The Planning Inspectorate
National Infrastructure
Planning
Temple Quay House
2 The Square
Bristol
BS1 6PN

Our ref: WX/2019/133441/01-L07
Your ref: TRO40011
Date: 01 December 2020

**METROWEST PHASE 1 DEVELOPMENT CONSENT ORDER (DCO) APPLICATION
SUMMARY OF WRITTEN REPRESENTATIONS
ENVIRONMENT AGENCY REFERENCE 20025331**

2.41 - Easton-in-Gordano Flood Mitigation Plan

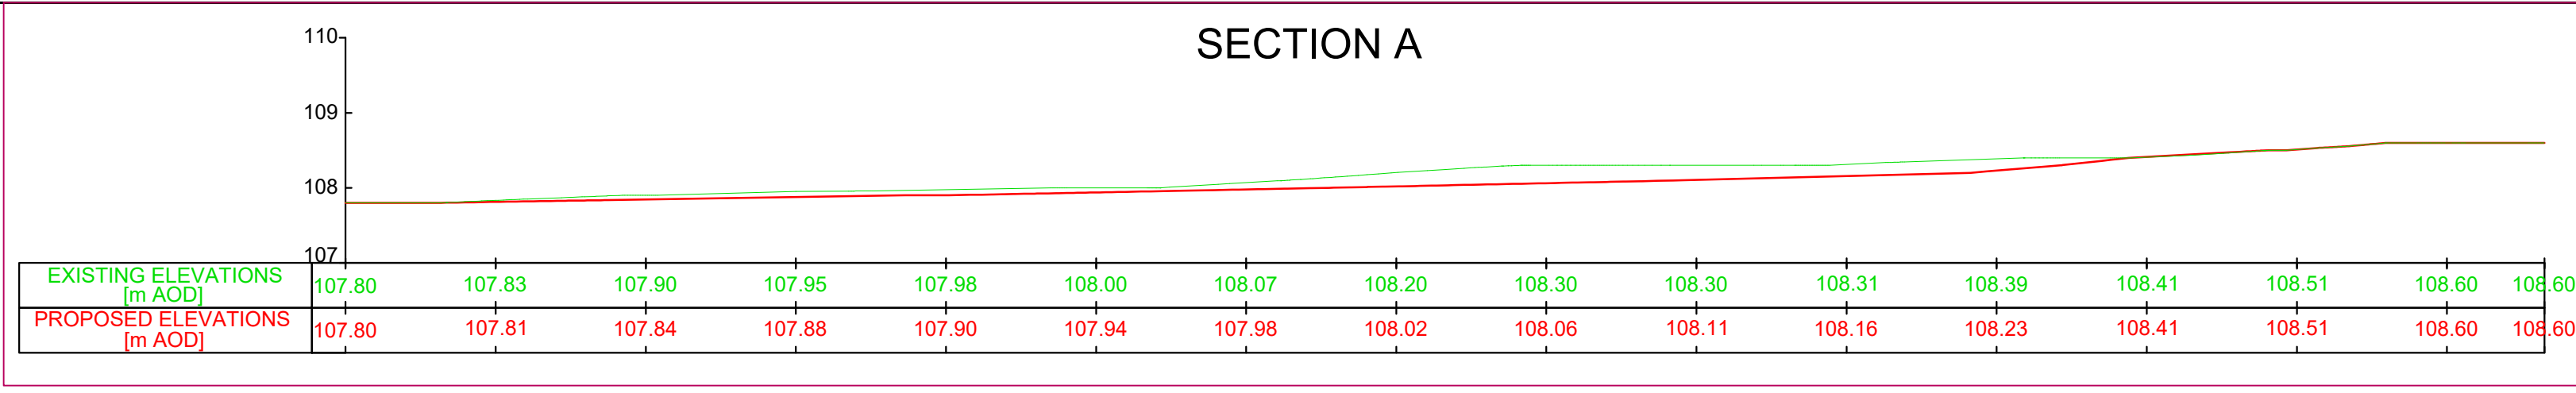
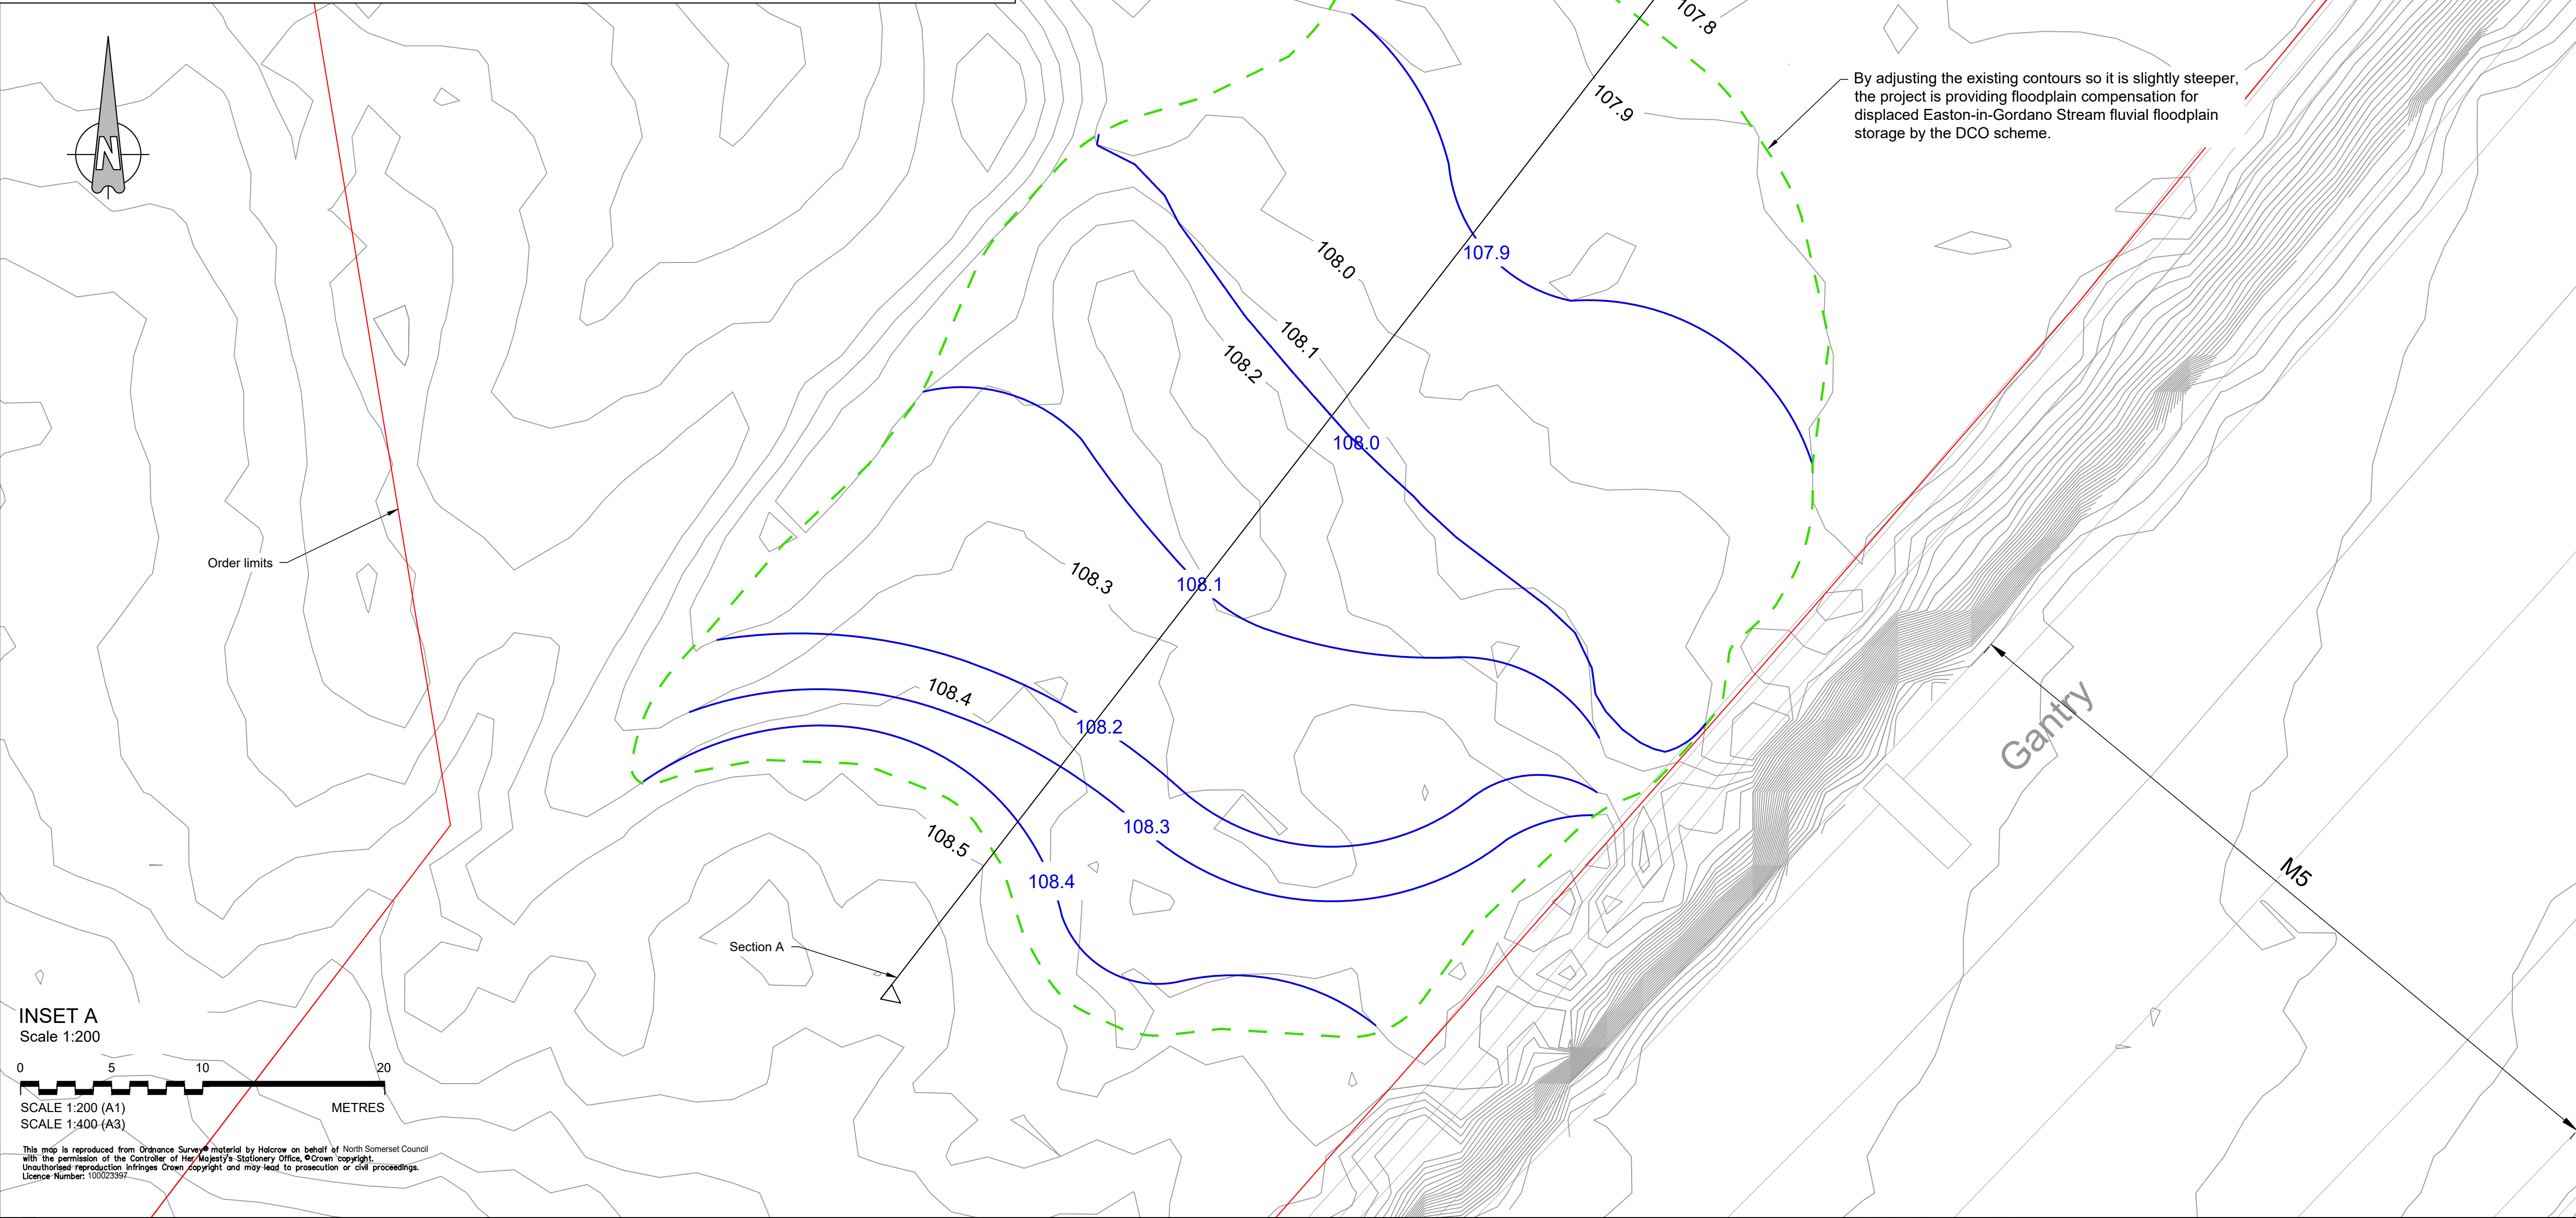
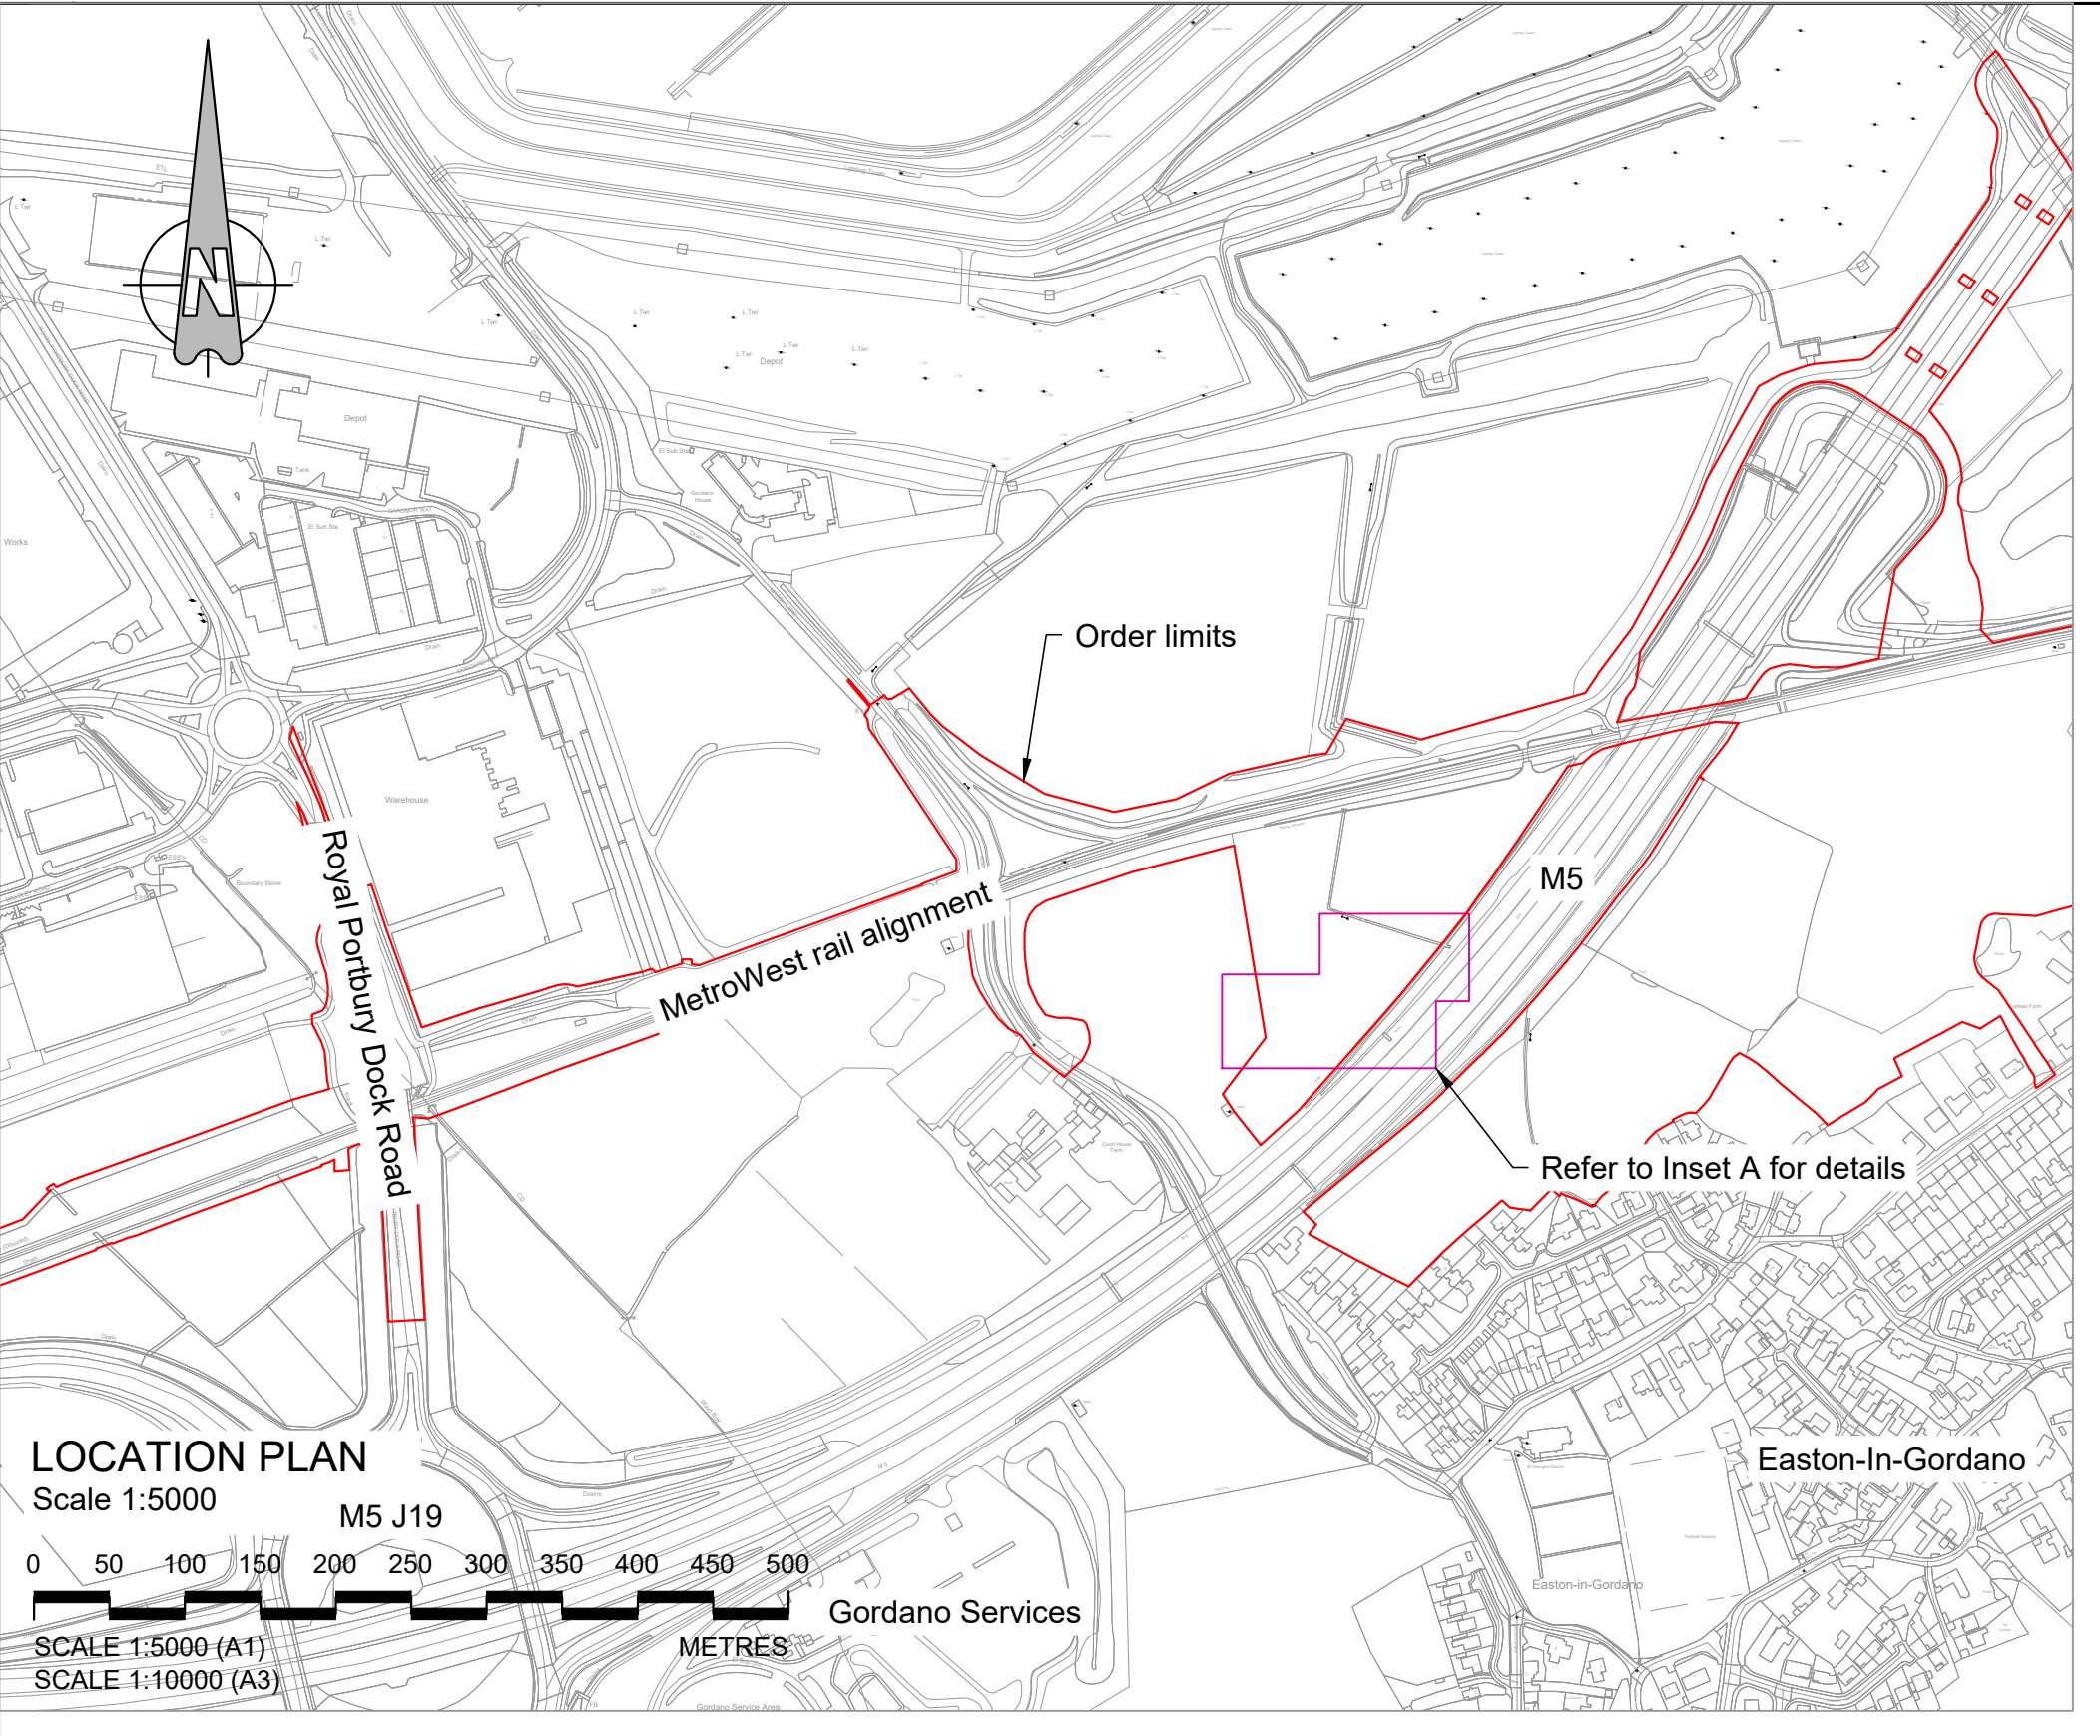
The FRA concludes the Portishead to Pill section of the scheme is above the fluvial and tidal 1 in 1000 year flood level, for present and future scenarios (2075 and 2115). However, this relies on a flood relief channel in the form of a farm access track running under the railway line. As a result, appropriate provisions are required within the DCO, to ensure the farm access track will be maintained for the lifetime of the development.

At that location, the railway needs to be realigned, which will result in a loss of floodplain storage. The model has identified a loss of floodplain storage of 75.5 m³ as a result of realigning the railway. The Agency has advised that, on the basis of the storage volume stated, it would not require the provision of floodplain compensation.
